Rezoning Transportation Analysis

Petition Number: 2020-165

General Location Identifier: Tax ID 02516105.

Date	Description
12-28-20	First Review (EL)
1-21-21	Second Review (EL)
2-24-21	Third Review (EL)

RZ1.00

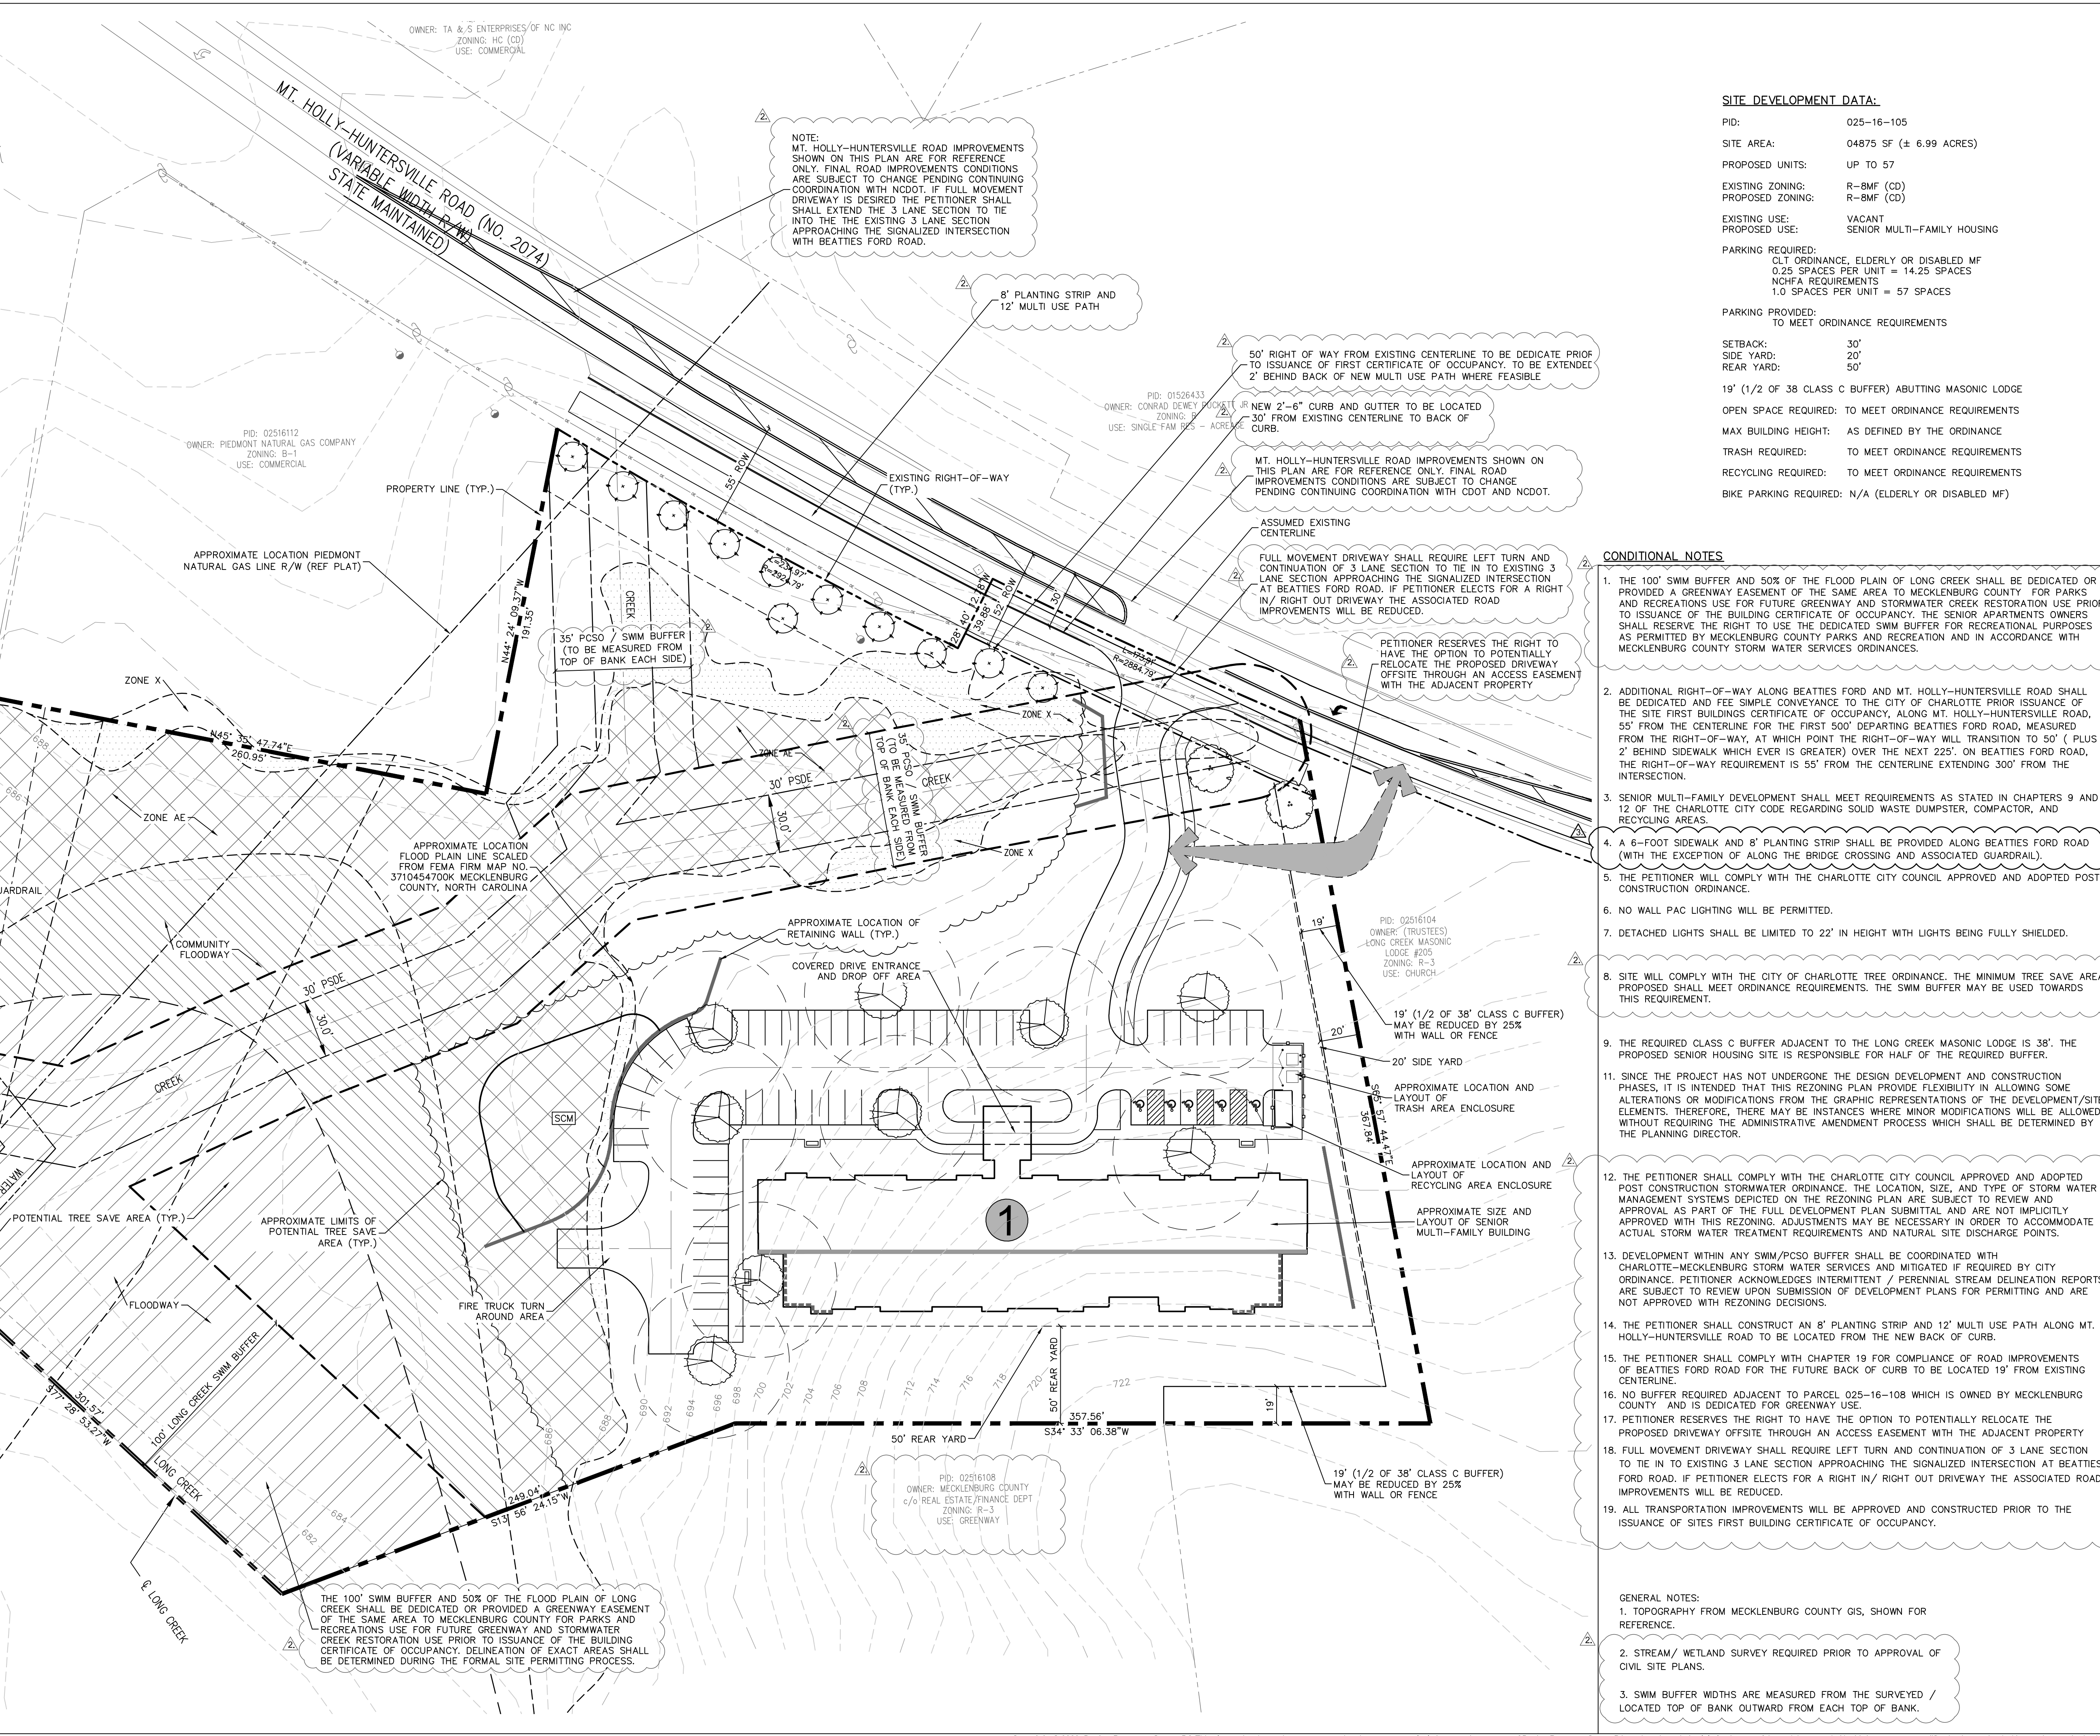
9. ~~A site plan note(s) specifying dedication and fee simple conveyance of all rights-of-way to the City before the site's first building certificate of occupancy is issued is needed. CDOT requests rights-of-way set at 2' behind back of sidewalk where feasible.~~
10. ~~A site plan note specifying that all transportation improvements will be approved and constructed before the site's first building certificate of occupancy is issued is needed. The petitioner may phase transportation improvements if said improvements and phasing are explicitly described in site plan notes.~~
11. **New Comment** (site plan dated 1.11.2021) ~~Site plan and conditional note (4) revisions are needed to clarify the following conditional note corrections, shown below.~~

12 OF THE CHARLOTTE CITY CODE REGARDING SOLID WASTE DUMPSTER, COMPACTOR, AND RECYCLING ~~4~~ **6'** L.A.S.

4. A ~~5~~ FOOT SIDEWALK AND 8' PLANTING STRIP SHALL BE PROVIDED ALONG ~~M.H.~~ **Remove; MHH will have a 12' MUP per note 14** HOLLY HUNTERSVILLE ROAD FRONTAGE AND BEATTIES FORD ROAD (WITH THE EXCEPTION OF ALONG THE BRIDGE CROSSING AND ASSOCIATED GUARDRAIL).

RZ1.00

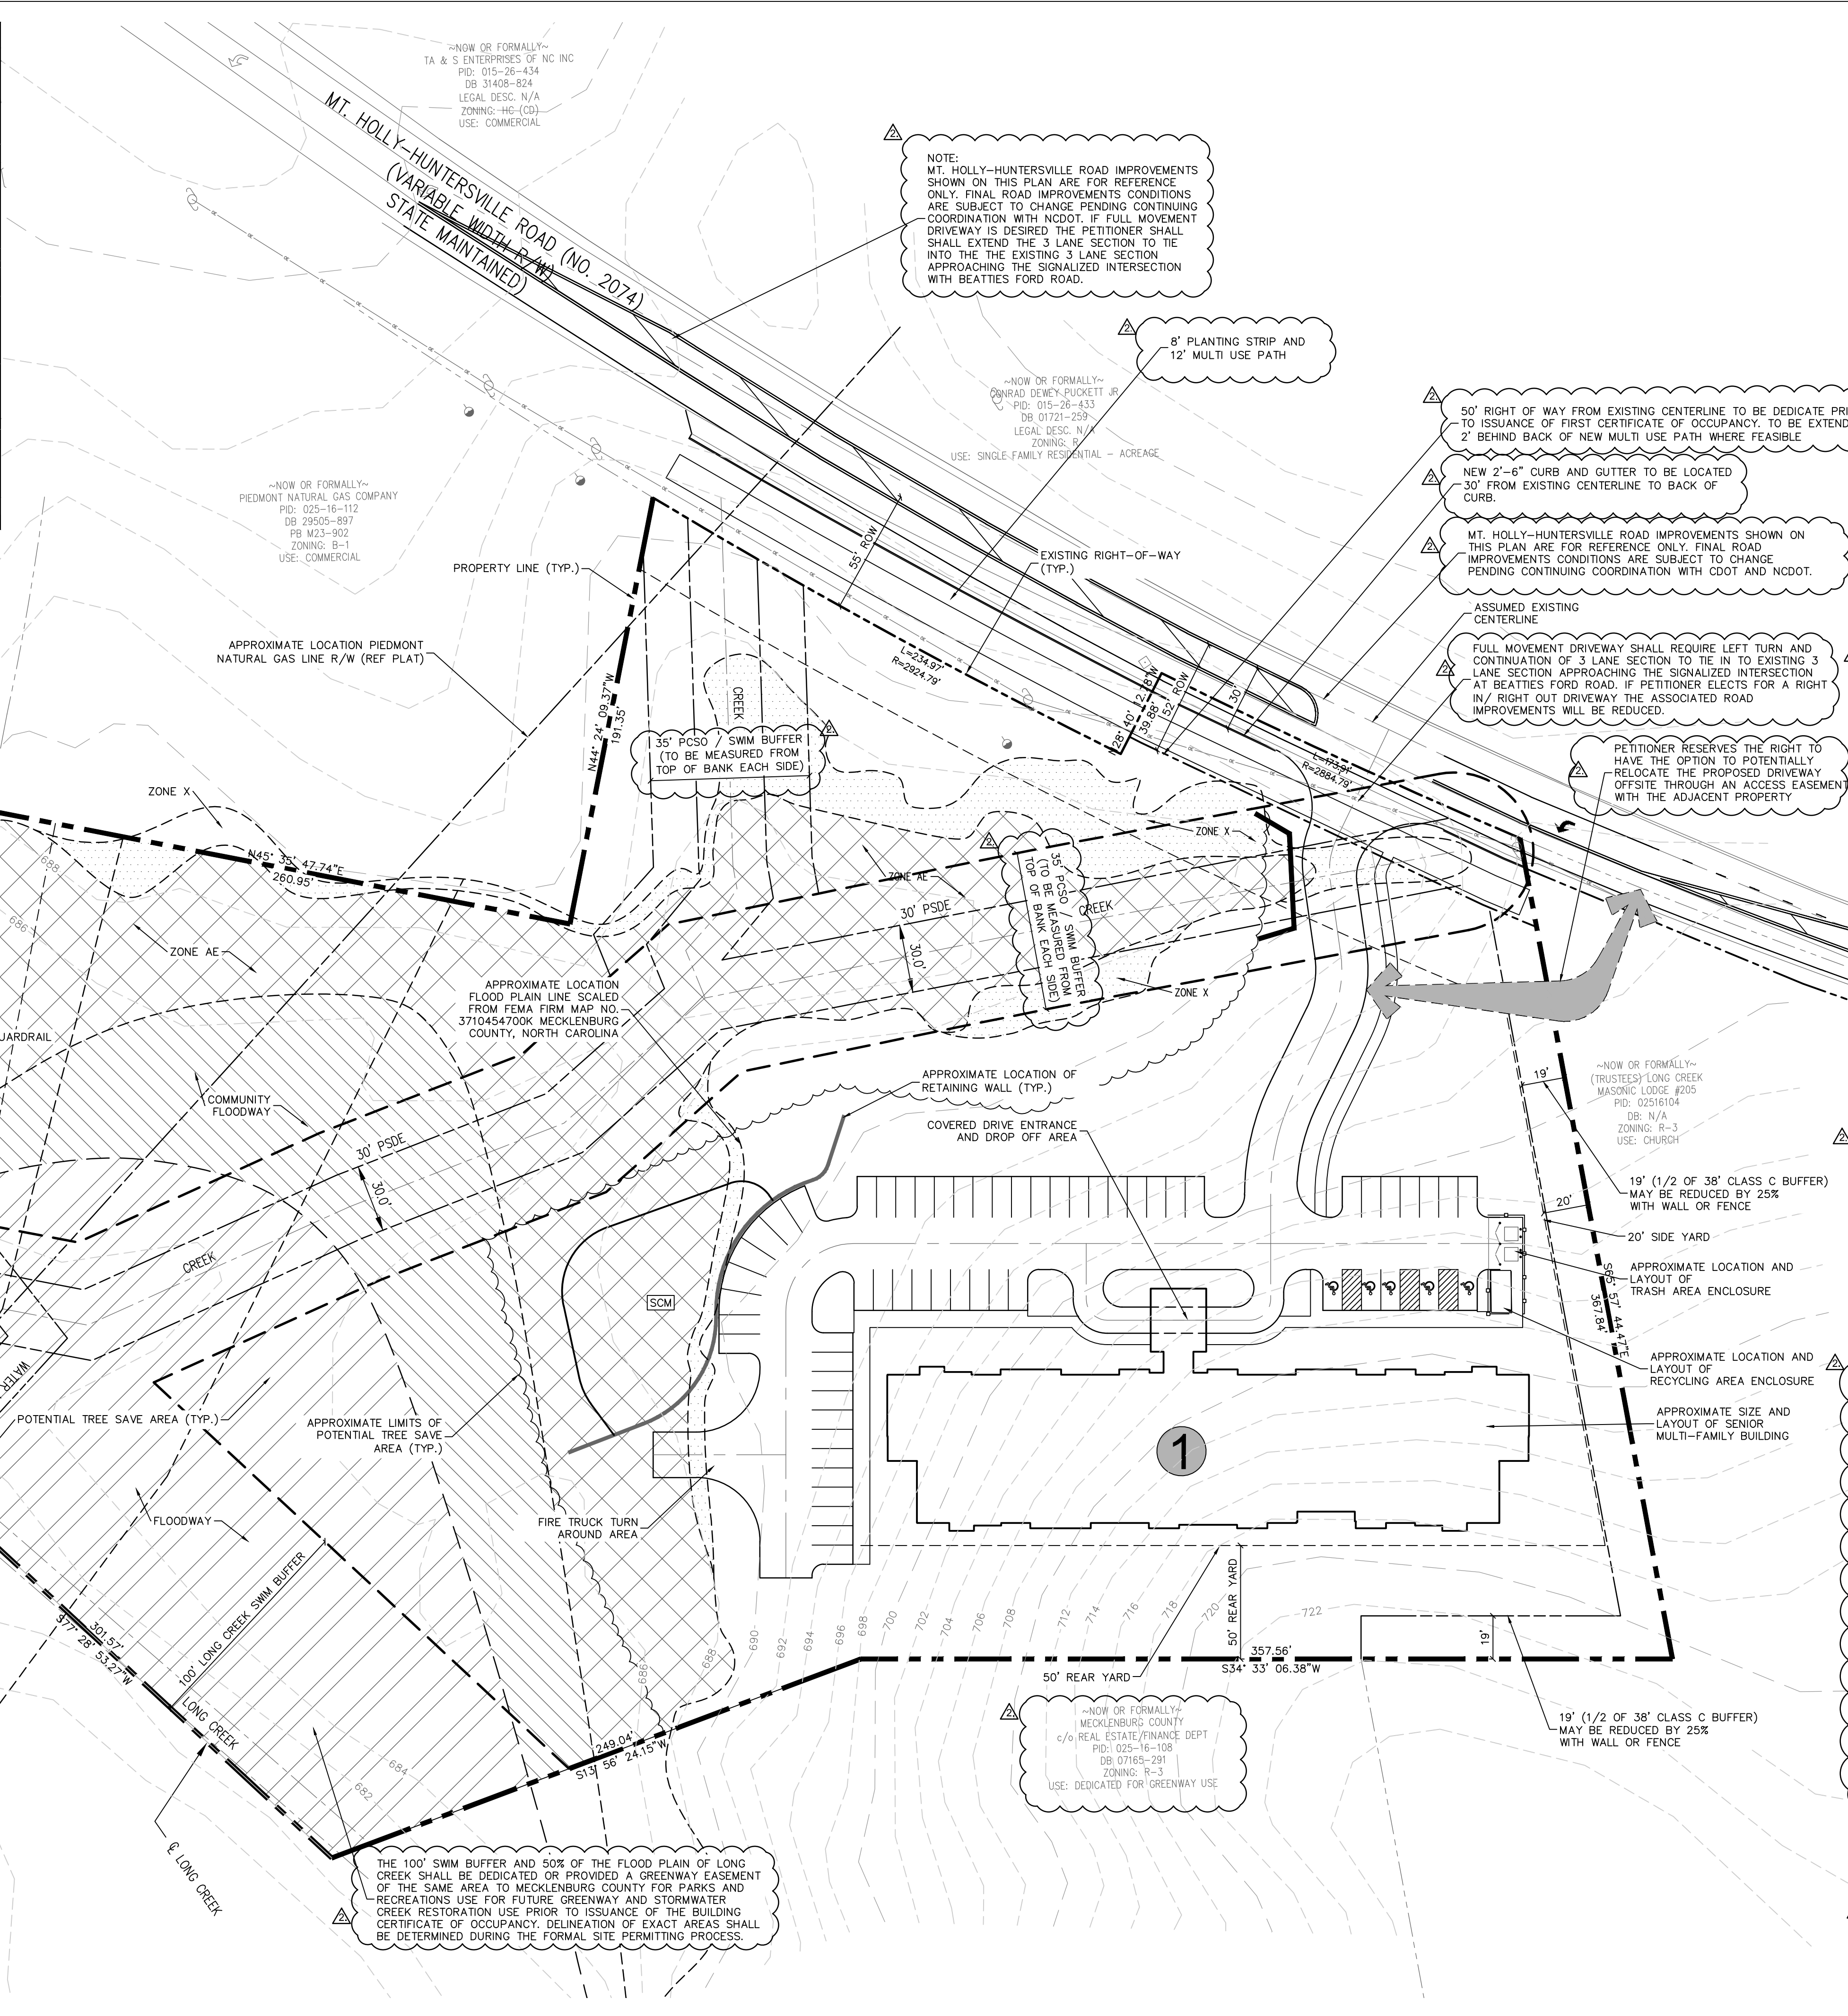
1. ~~Curbline:~~

- a. ~~**Mount Holly Huntersville Road:** The future location of curb and gutter is 30 feet from centerline to the proposed back-of-curb, to accommodate a future 4+ Avenue road cross section.~~
- b. ~~**Beatties Ford Road:** The future location of curb and gutter is 19 feet from centerline to proposed back-of-curb, to accommodate a future 2+ Avenue road cross section.~~

~~Label and dimension the curb and gutter from the centerline for each road on the site plan.~~

~~3. Revise site plan and conditional note(s) to commit to dedicate a minimum of 50 feet of public right-of-way from the Mount Holly Huntersville Road centerline. Label and dimension the right-of-way from the road centerline.~~

~~4. Revise site plan and conditional note(s) to commit to dedicate a minimum of 38 feet of public right-of-way from the Beatties Ford Road centerline. This request is greater than the required 35 feet of right-of-way to be reserved for a minor thoroughfare, in order to accommodate the future 2+ Avenue cross section. Label and dimension the right-of-way from the road centerline.~~

~~5. Revise site plan and conditional note(s) to commit to construct a required minimum 8-foot planting strip and a requested 12-foot shared-use path in lieu of the required 6-foot sidewalk on Mount Holly Huntersville Road, as required per Chapter 19 of the City Code. The requested 12-foot shared-use path meets the City Charlotte BIKES Plan and the goal to improve pedestrian and bicycle connectivity throughout the City. Label and dimension both items from the back-of-curb and gutter and road centerline.~~

~~6. Revise site plan and conditional note(s) to commit to comply with the requirements of Chapter 19 of the City Code, to address the road improvements required along Beatties Ford Road.~~

~~7. In coordination with NCDOT, revise the site plan and conditional note(s) to construct a left turn lane on Mt. Holly Huntersville Rd, with a three-lane section extending to the signalized intersection with Beatties Ford, if a full movement access on Mount Holly Huntersville Road is desired. To limit pavement widening, a right-in/right-out access may be proposed on Mount Holly Huntersville Road, if constructed per NCDOT standards.~~

8. ~~CDOT recommends revising the site plan and conditional note(s) to acquire an access easement from PID 02516104, to avoid impacting the stream and constructing the proposed culvert crossing.~~
